STERLING RECYCLING FACILITY

SECTION 5 IN TOWNSHIP 12 SOUTH RANGE 65 WEST OF THE 6TH PRINCIPAL MERIDIAN EL PASO COUNTY, CO SITE DEVELOPMENT PLAN

PPR-22-041

V2_Site Development Plan.pdf Markup Summary

### DEVELOPMENT PLAN

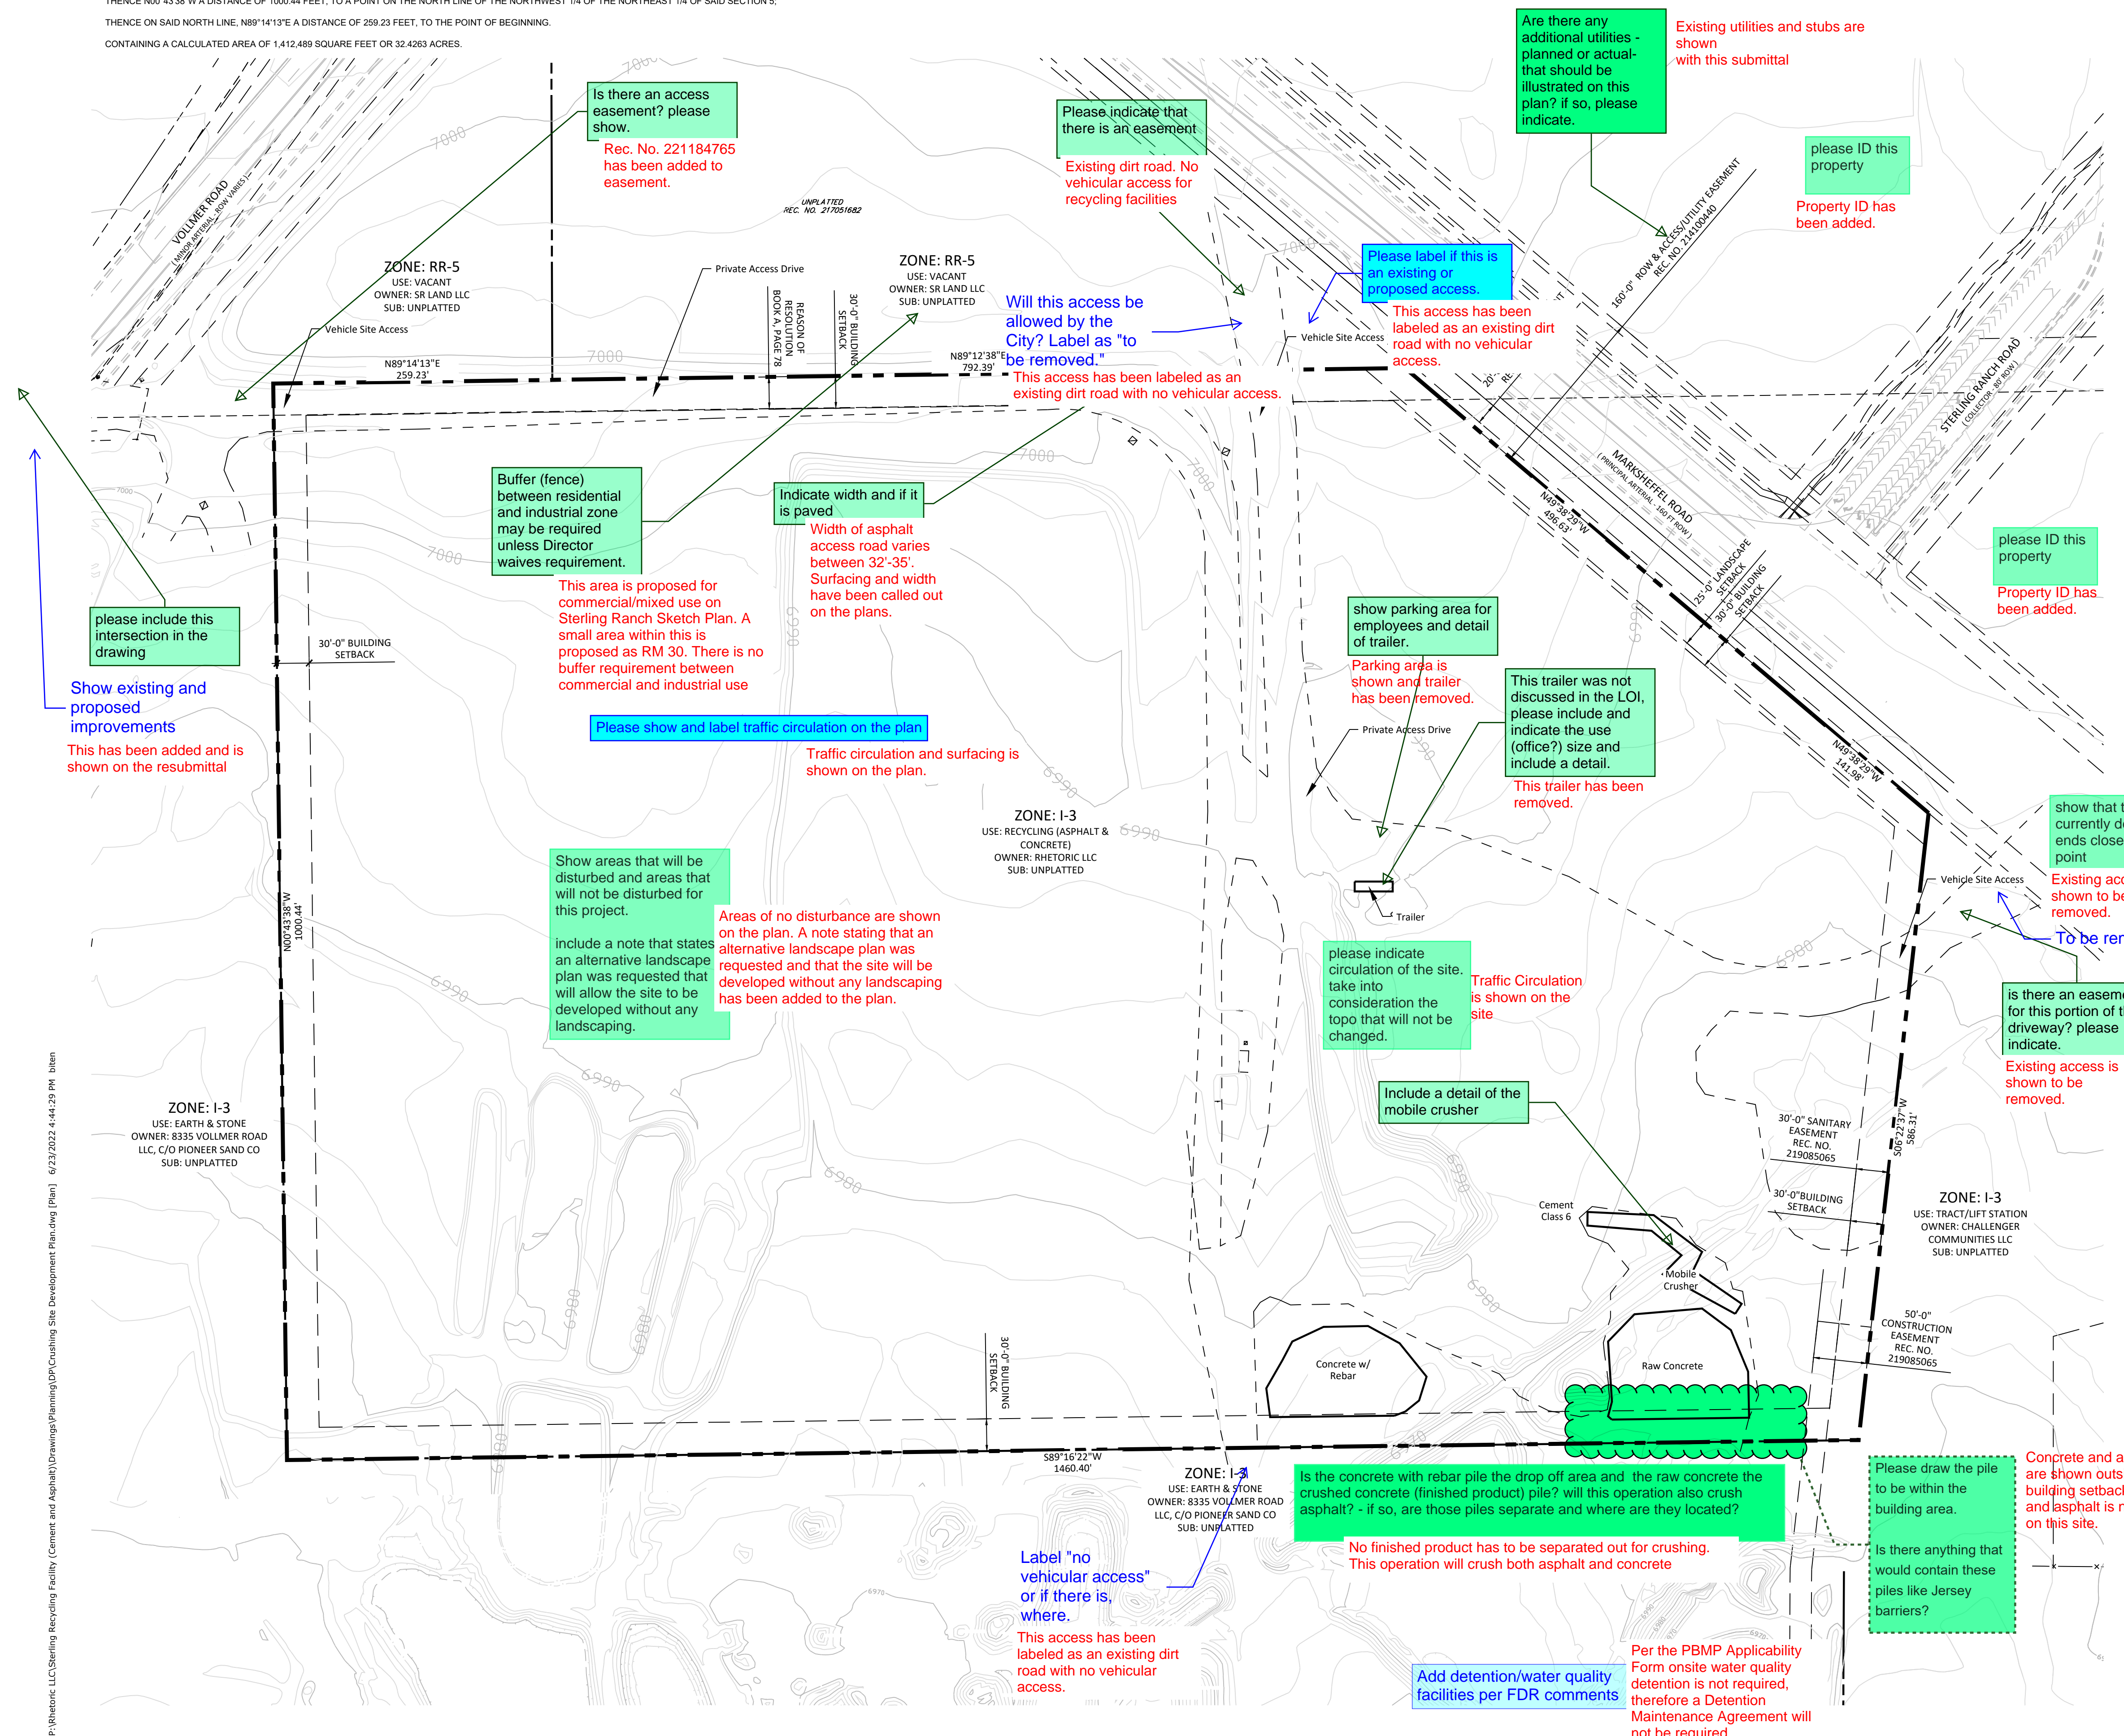
Add a callout and a note identifying improvements to Vollermer Road discussed in the traffic memo.

Extend traffic arrows to Vollermer Road.

Add a callout and a note identifying improvements to Vollmer Road discussed in the traffic memo.

Extend traffic arrows to Vollmer Road.
